From: [McAllister, Jo](#)
To: [A303 Sparkford to Ilchester](#)
Cc: [Woodhouse, Helen](#); [Harries, Beth](#); [South West Casework](#)
Subject: TR010036 - A303 Sparkford to Ilchester Dualling Project
Date: 16 September 2020 18:05:36
Attachments: [image001.jpg](#)
[image36h2af.JPG](#)
[A303 Sparkford Ilchester DCO_HBMCE response letter_160920.pdf](#)

Application by Highways England for an Order Granting Development Consent for the A303 Sparkford to Ilchester Dualling
Reference: SPIL-SP0005 and 2001-4933

Application by Highways England for an Order Granting Development Consent for the A303 Sparkford to Ilchester Dualling

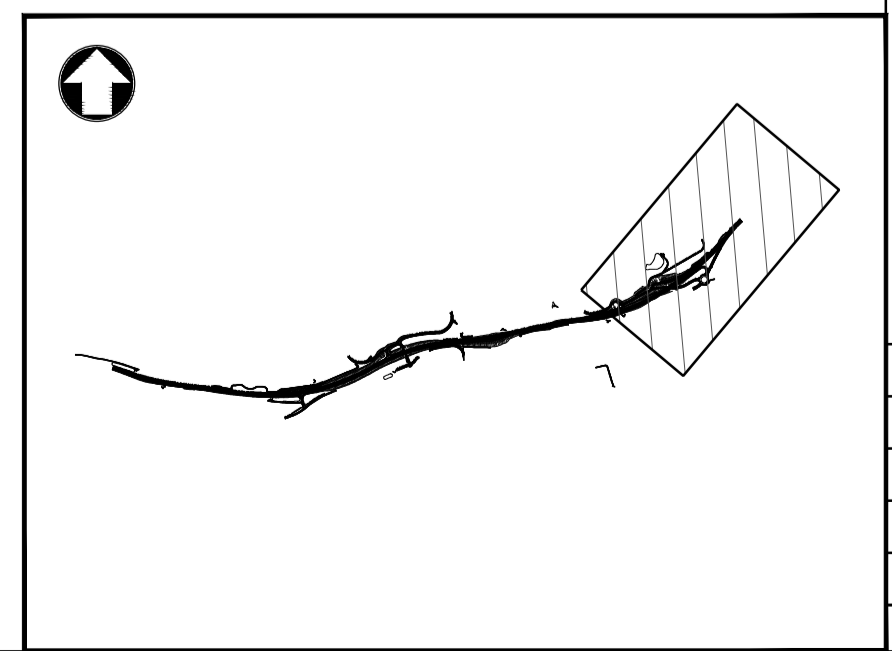
- 2.8. The Secretary of State has requested information from the Applicant as to whether lighting of Hazlegrove Underbridge at night can be delivered. The Applicant advises that it could be delivered but it would have to include lighting of the carriageway and entrances at either end. This would comprise an estimated 24no. 10 metre-high lighting columns. They advise that this would increase the modern road network character in key views from the park and Hazlegrove House. After undertaking a high-level environmental

assessment, they consider that this would have an additional adverse effect on the landscape character of Hazlegrove House RPG, and the visual amenity from Hazlegrove House, thus increase the significant cultural heritage impacts on the two designated assets.

2.9. The Secretary of State has also been critical of the lack of lighting on the de-trunked section of the A303 at Hazlegrove (re. the Examining Authority's Recommendation Report, section 11.6). The Applicant advises that the introduction of additional lighting along the de-trunked section would bring a further 19 light columns into the view from viewpoints (38 & 39) within the RPG. As such, they consider that the significant permanent construction and operational effects reported for Hazlegrove House and the RPG in the ES would remain and be increased by the additional lighting required.

2.10. In our Written Representation (Historic England - Deadline 2 Submission - Written Representation & suggested locations for site inspection, p.29) we considered that whilst the proposed false cuttings and woodland planting would screen much of the road from the RPG, they would not be sufficient to screen large vans, coaches and HGVs. Therefore, this would also apply to high level lighting (10m high columns) extending west from Hazlegrove Junction into key views from the House. We would concur that there may be an increase in the level of harm to the designated assets arising from this additional lighting. As a result, additional mitigation measures may need to be evaluated and implemented.
